Recommendation Report for Planning Permission for Works or Extension to a Dwelling

REF NO: BR/148/19/HH

LOCATION: 25 Ash Grove
Bognor Regis
PO22 9JT

PROPOSAL: Single storey rear extension

Proposed Elevations

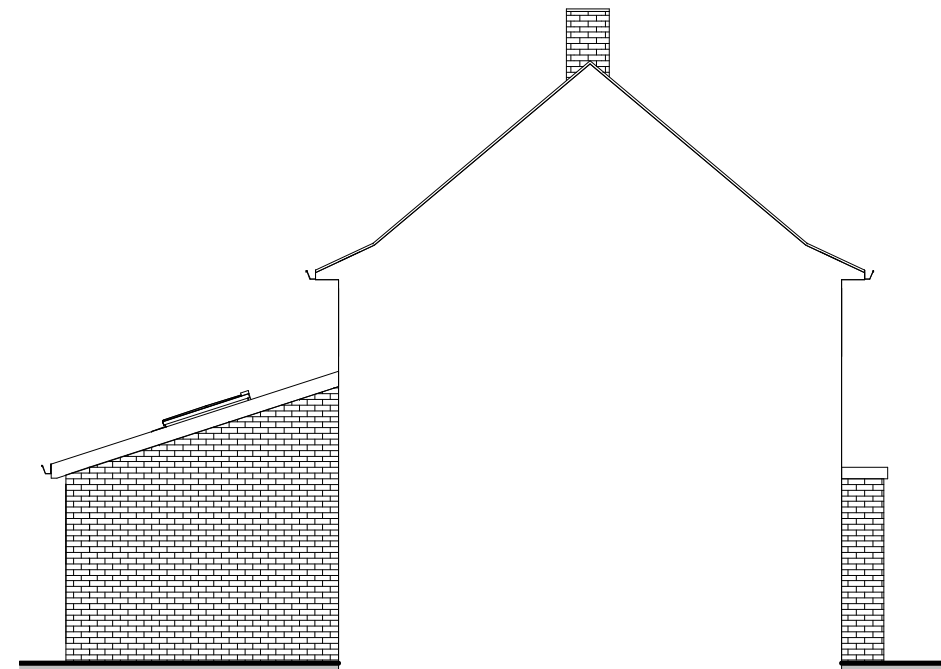
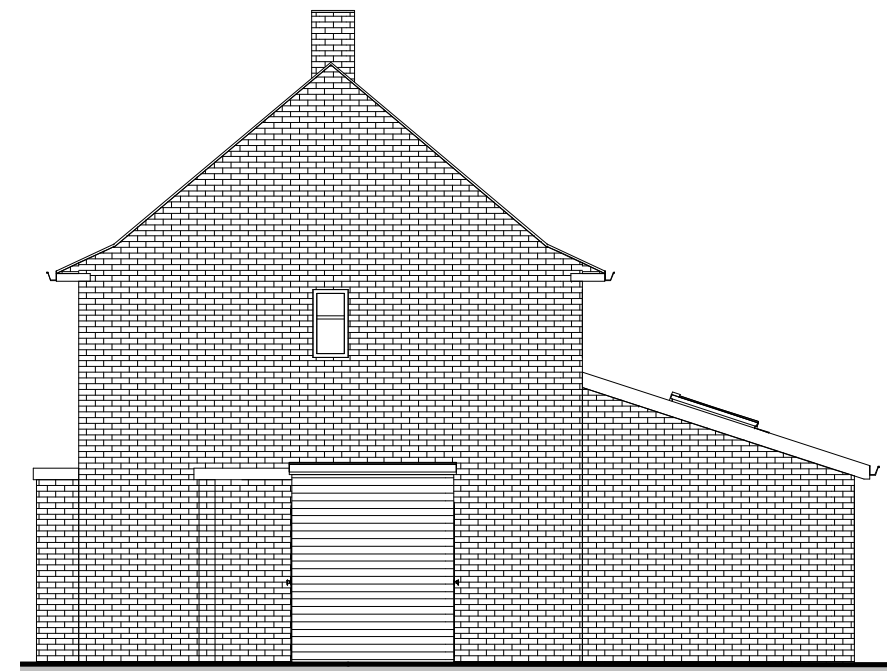
The proposed extension is situated to the rear of the dwelling and as a result is not visible from the street scene, it is not deemed to have a significantly detrimental impact on the established spatial pattern, or visual amenity of the area. The extension due to its design and siting is considered to appear subservient to the host dwelling with materials to match.

The proposed development is not considered to be in accordance with D DM1 and D DM4 of the Arun Local Plan. Therefore, the application is recommended for refusal due to its unacceptable detrimental impact on the neighbouring residential amenity. Additionally, as a result of its scale and massing having an unacceptable overbearing impact on the occupiers of the dwelling to the west at 27 Ash Grove.

Proposed Ground Floor
1 : 50

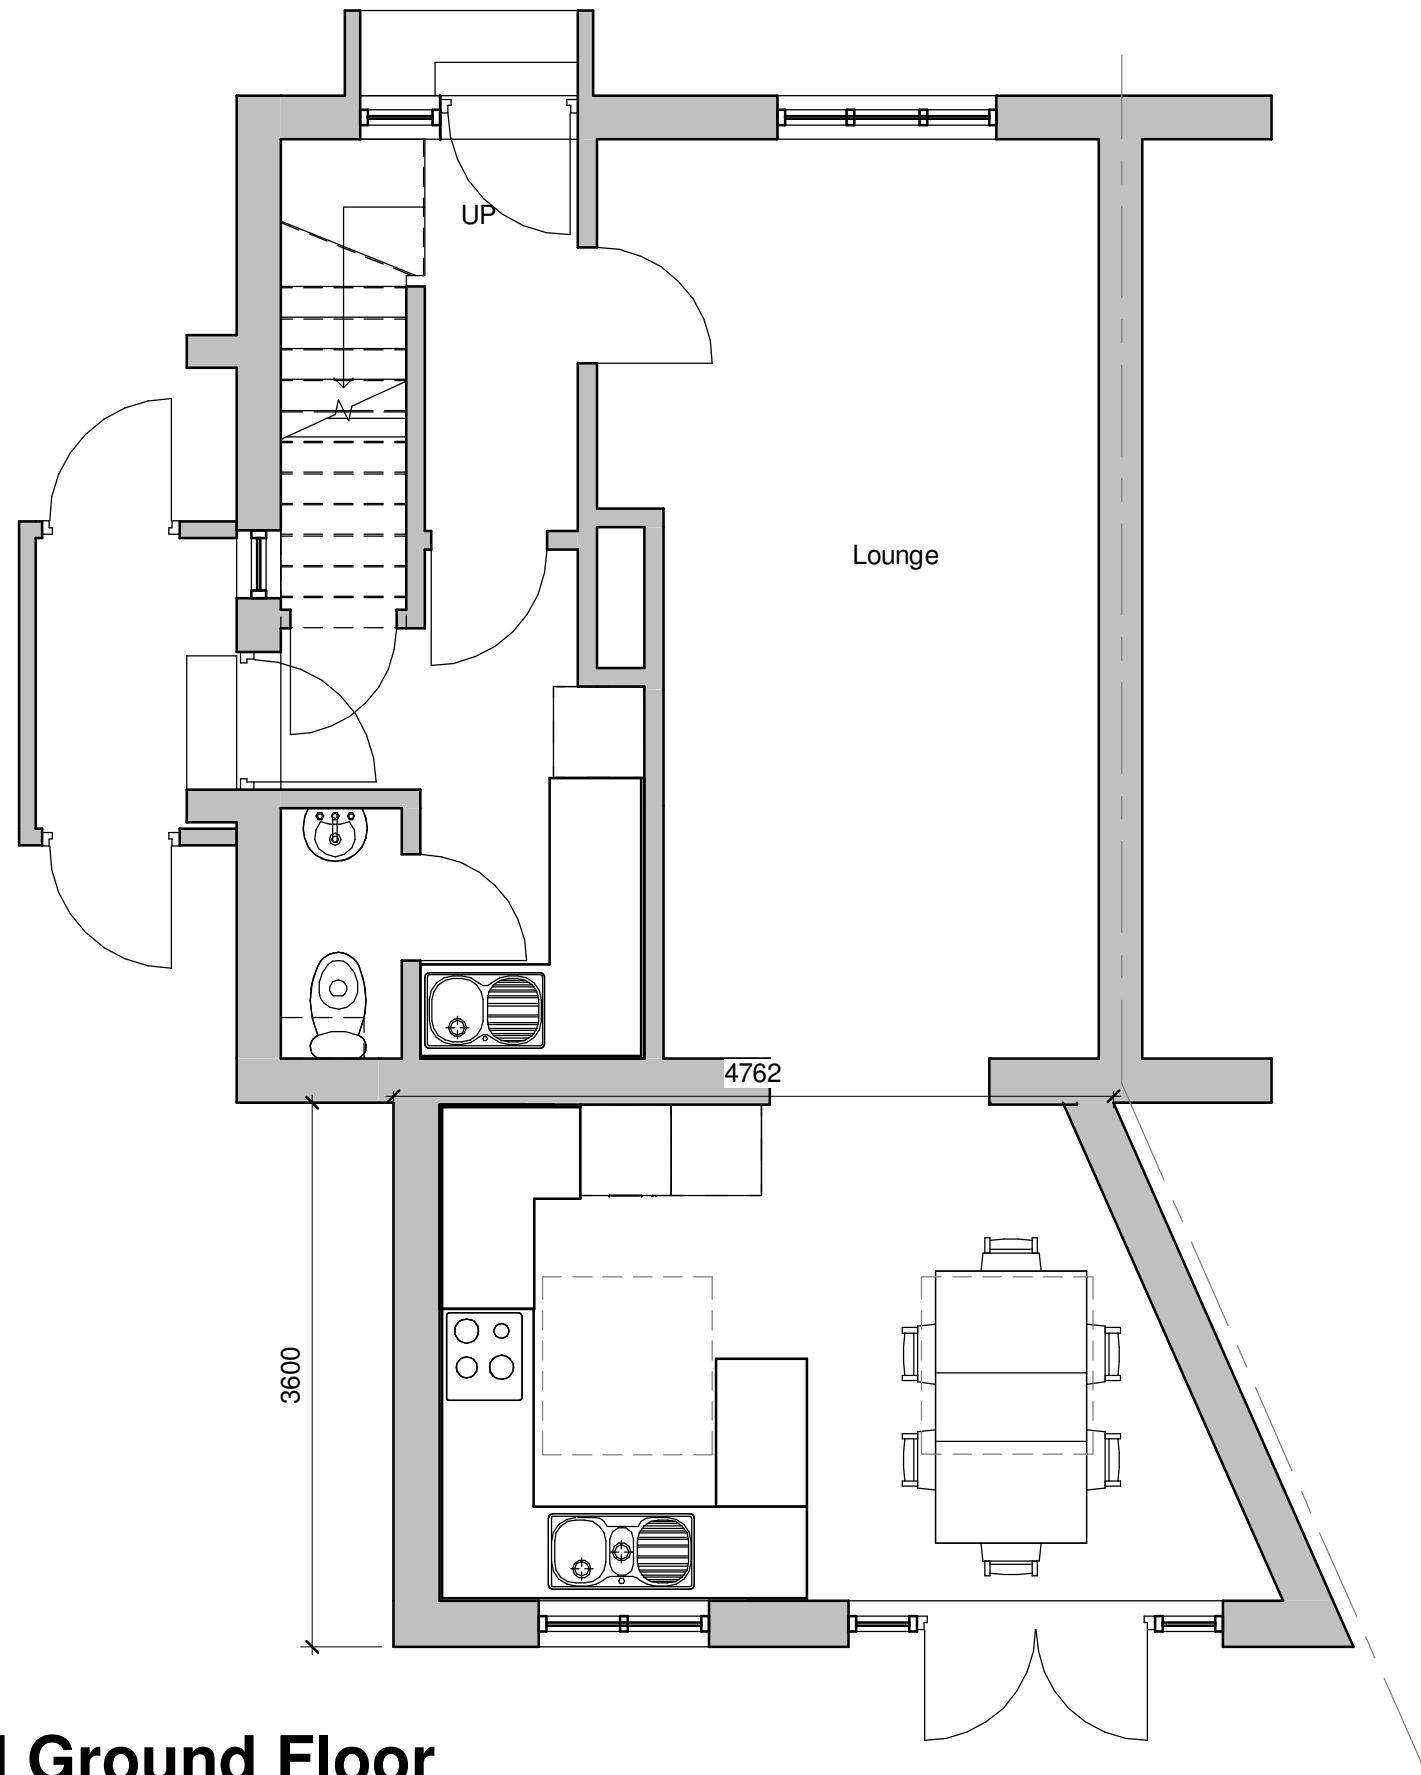
The proposed development is considered to have a significant impact upon the residential amenities of neighbouring dwellings. The proposed construction would be located 0.1m from the northern boundary, 22.5m from the eastern boundary and 1.3m from the southern boundary. The proposed window and doors are sited on the eastern elevation not gaining a view of any neighbouring dwellings. As the proposal is single storey it is considered to mitigate any potential for loss of privacy however, the proposed extension is deemed to break the 45 degree ruling as the extension runs along the boundary. The neighbouring property has French doors located closely to the boundary and the proposed development would then cast a shadow over said doors. The extension would impact on the private amenity space of the neighbouring property and thus is not considered to not be in accordance with D DM1(3) and D DM4(c) of the Arun Local Plan.

- 1 The proposed ground floor extension, by virtue of their scale, siting, size and proximity to the boundary will have an unacceptable overbearing impact upon the neighbouring property, 27 Ash Grove, in conflict with policies D DM1 and D DM4 of the Arun Local Plan.
